**RE: Response to Department of Planning and Environment Request for Response to Submissions (SSD 8440 MOD 1) at 42 Honeysuckle Drive, Newcastle 2300**

**Our Ref: 17058**

This letter has been prepared in response to the correspondence from the Department of Planning and Environment (the Department) requesting a response be provided to submissions received during the exhibition period of the Modification for State Significant Development application SSD 8440.

Figure 3 – Approved Floor Plan and Proposed Modification to Floor Plan

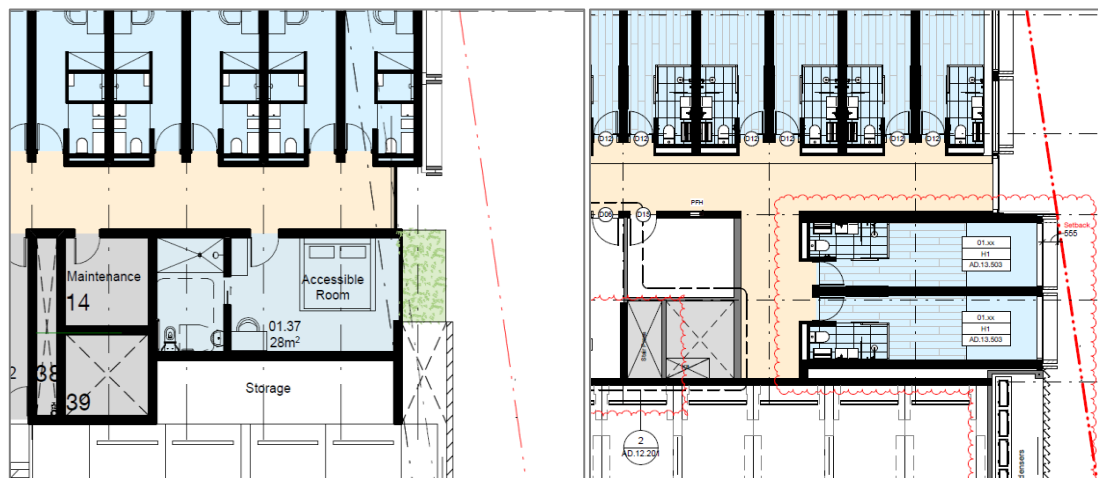
*According to the above report, the proposed modification involve alterations to the 'hotel units' (i.e. serviced apartments) in the south west corner on the ground floor. The plan extract from the approved floor plan shown in Figure 2 of the report (pg. 2) is in fact from an earlier superseded version. Given these circumstances it is recommended KDC are requested to confirm the overall increase in gross floor area of the development as indicated in the report is still correct.*

A revised gross floor area (GFA) schedule was submitted with the modification application. The schedule provided accurately reflect the requested changes to GFA. The extract of the existing arrangement was for reference only.

Figure 5 – Approved Western Elevation and proposed Western Elevation

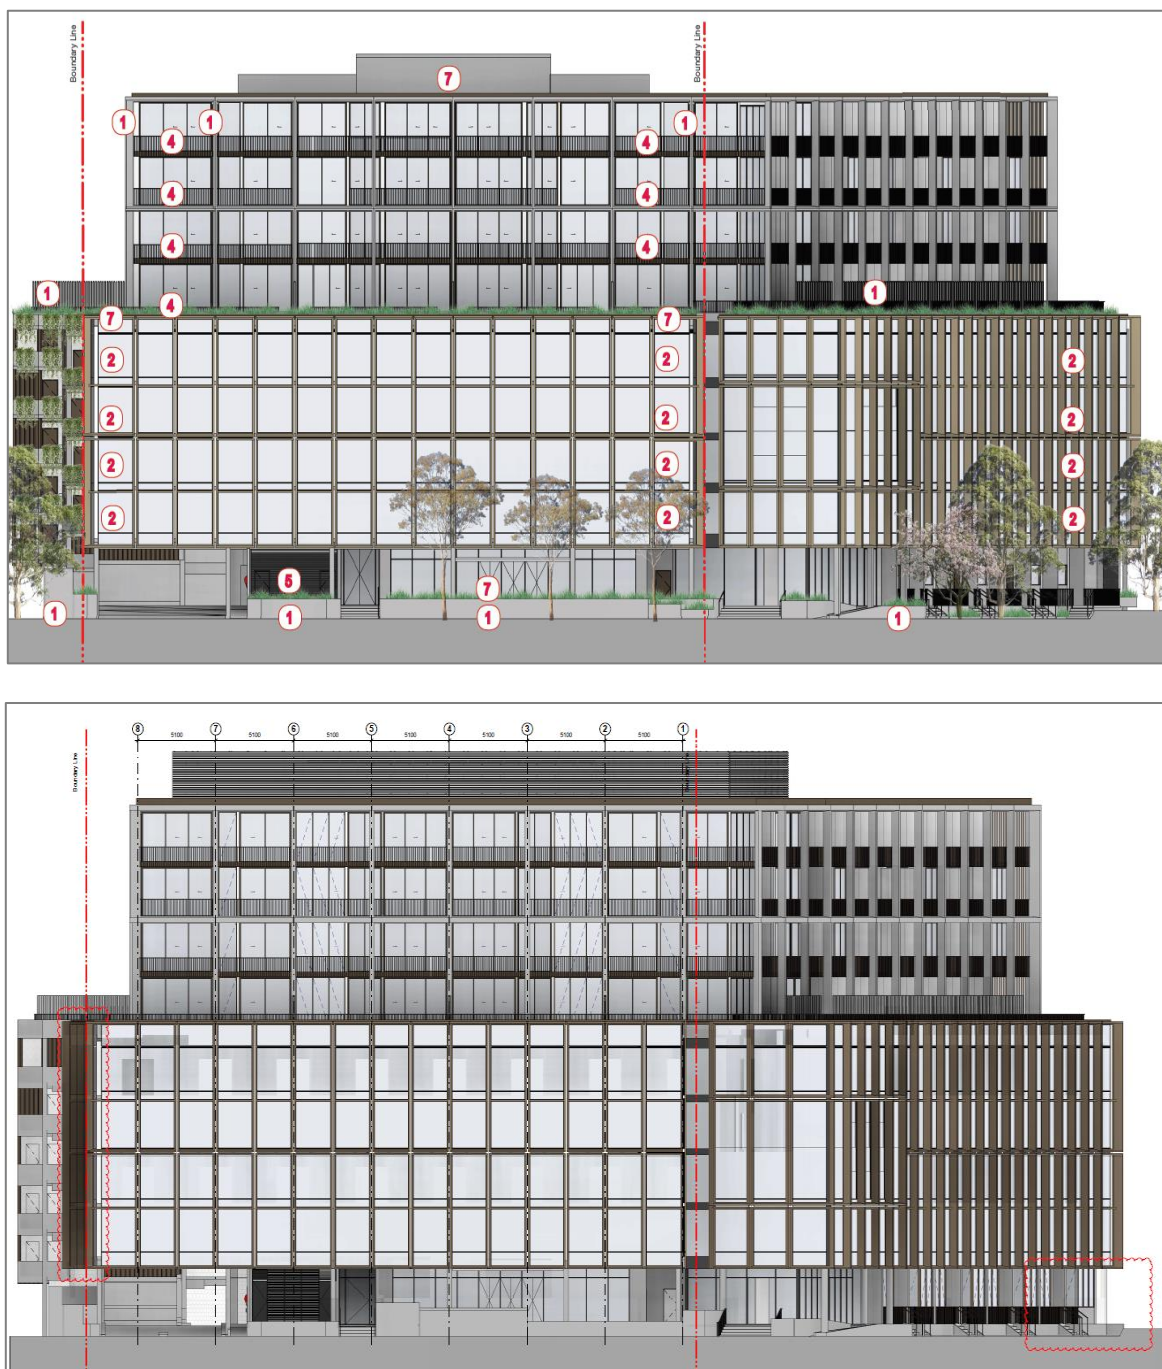
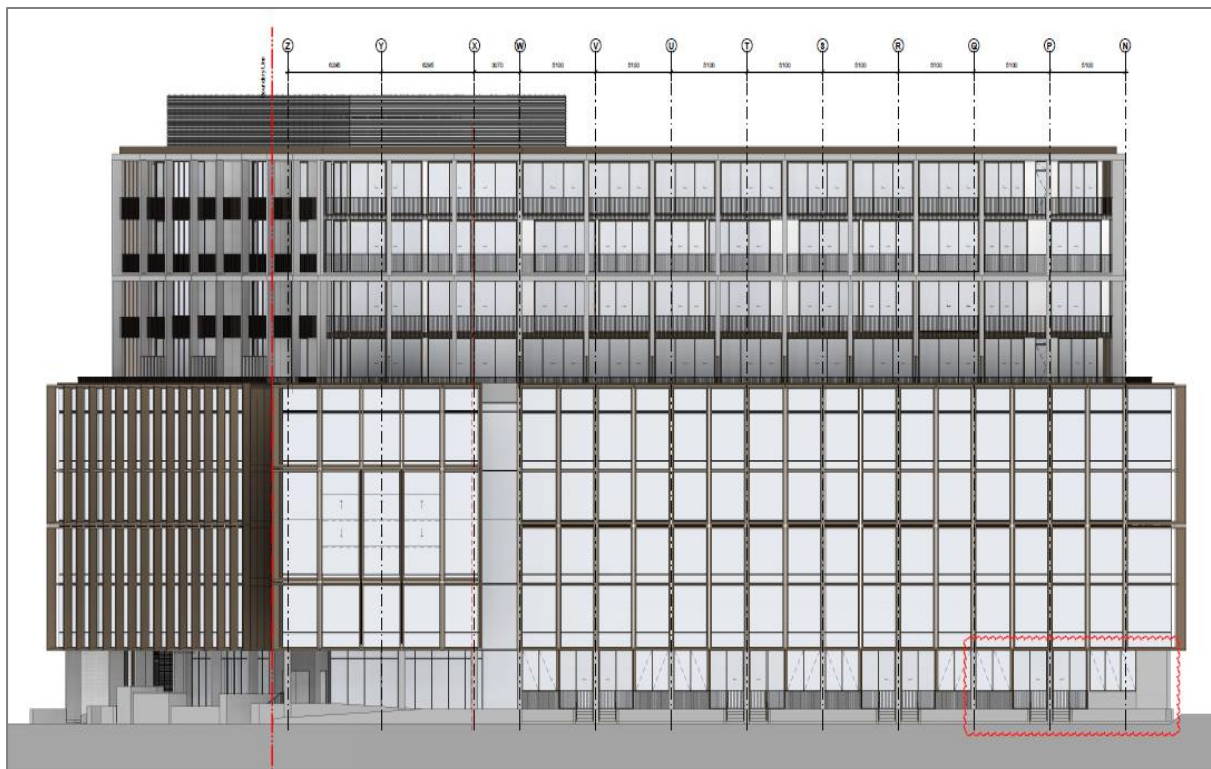
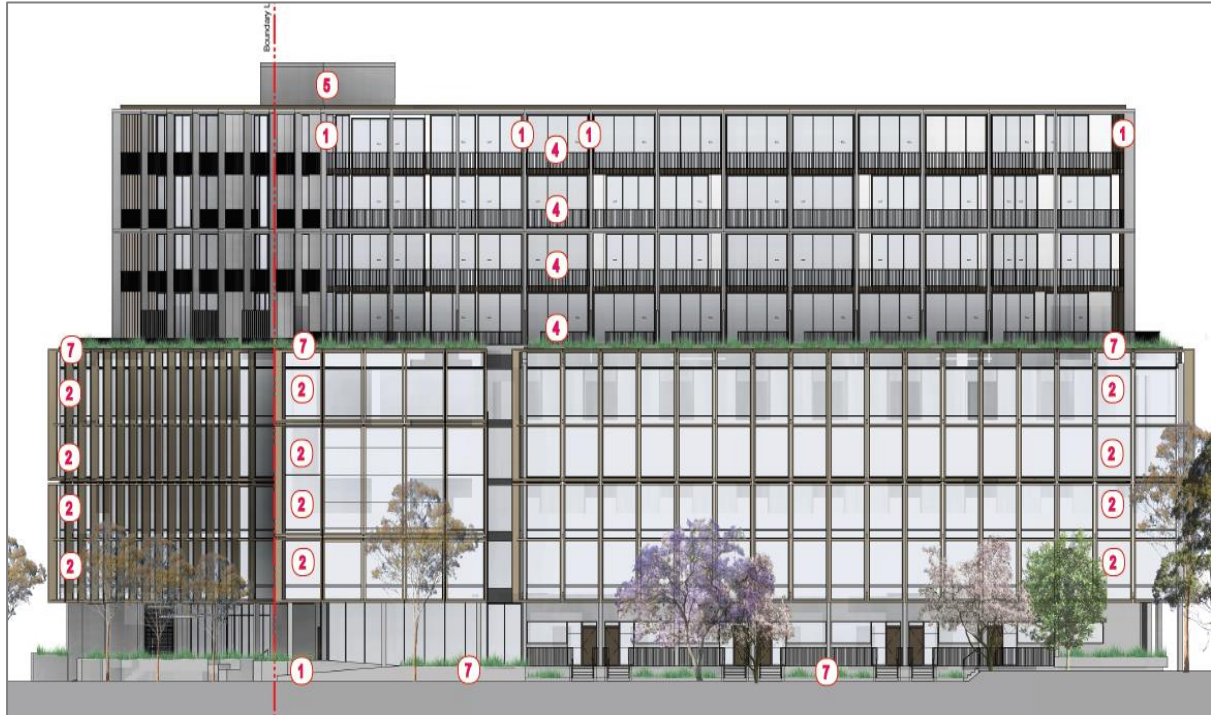
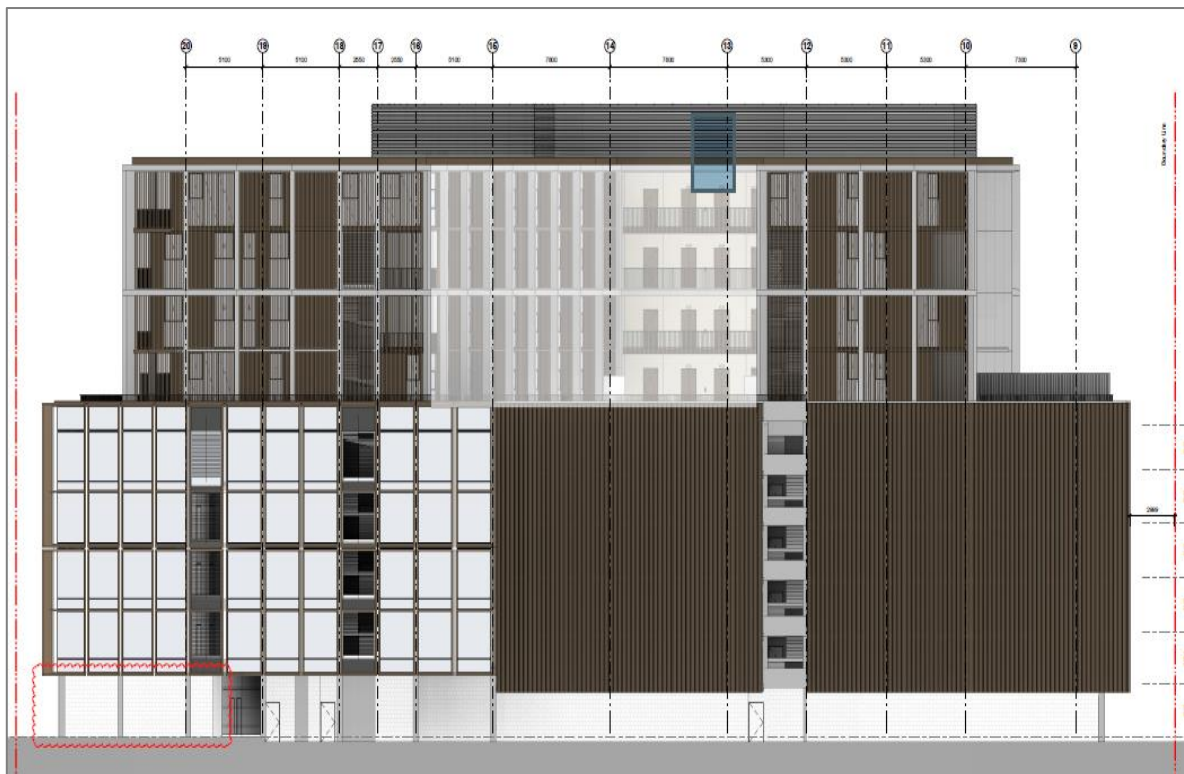
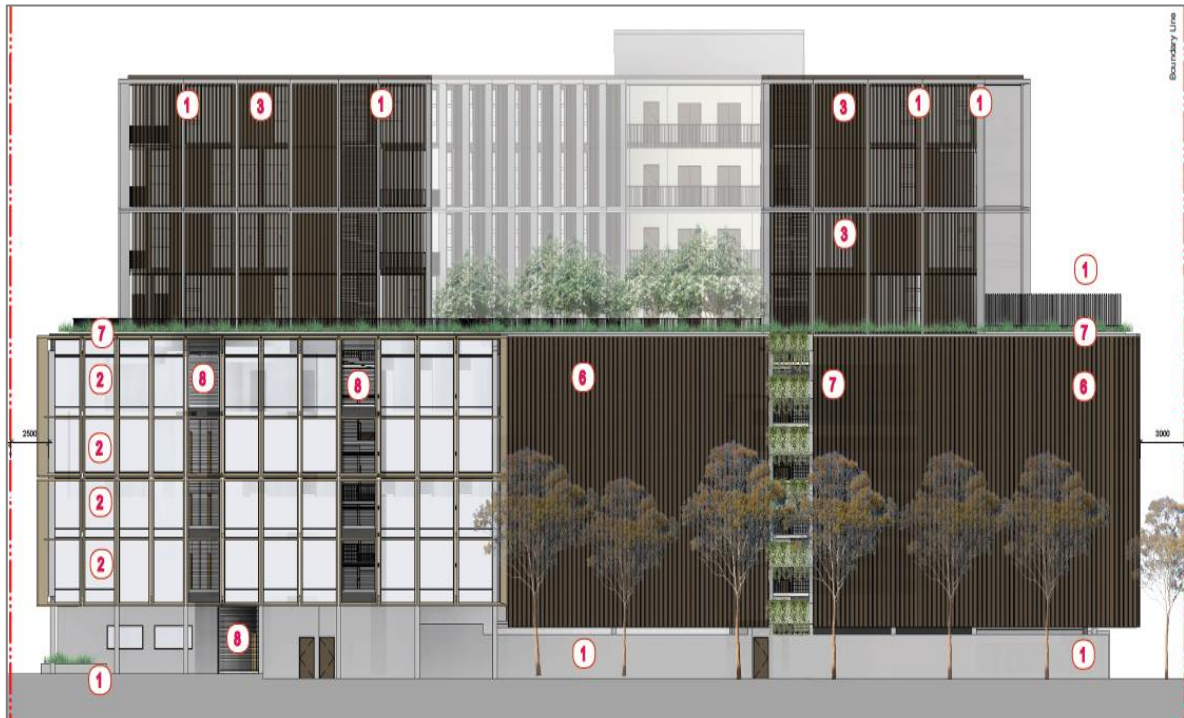
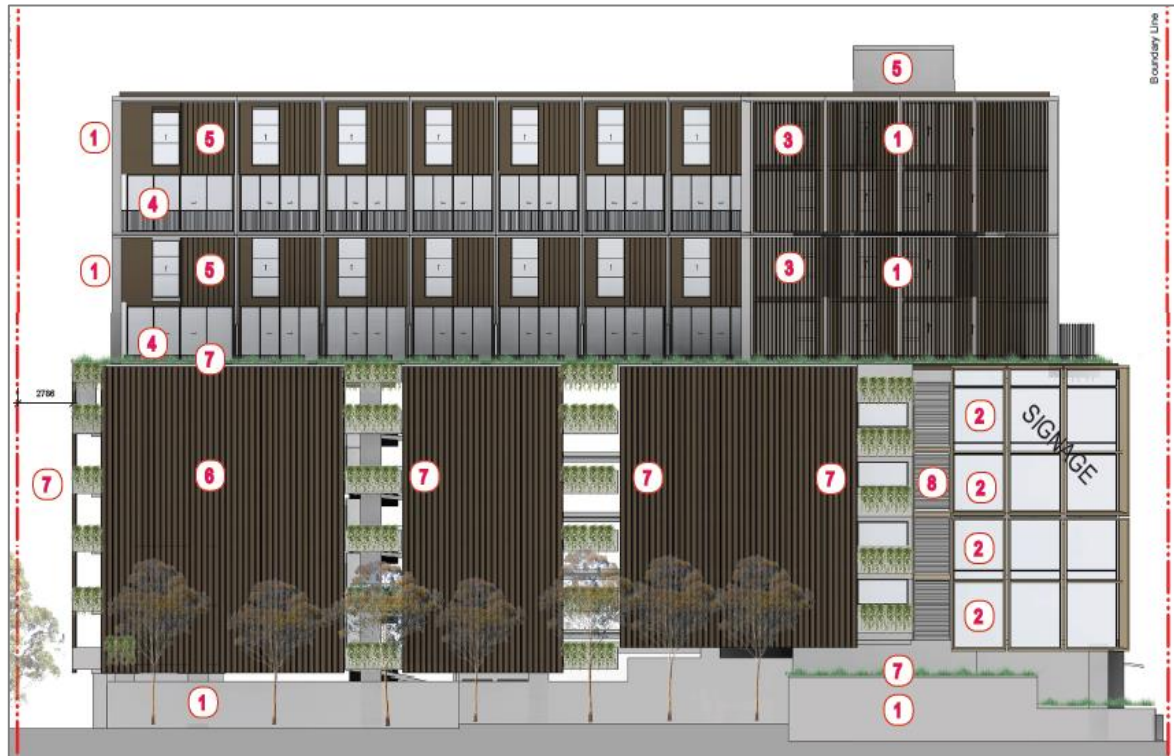
*Apart from the alterations to the accessible hotel rooms cited in the report, it is noted a number of other modification are indicated on the submitted amended plans for which no explanation has been provided. Notably the modification to the 'plant level' as depicted on the amended elevations.*

Regarding other changes shown on the plans to the ground level and plant level, these changes are considered to be minor, and are the result of the architectural plans progressing to detailed construction drawings.
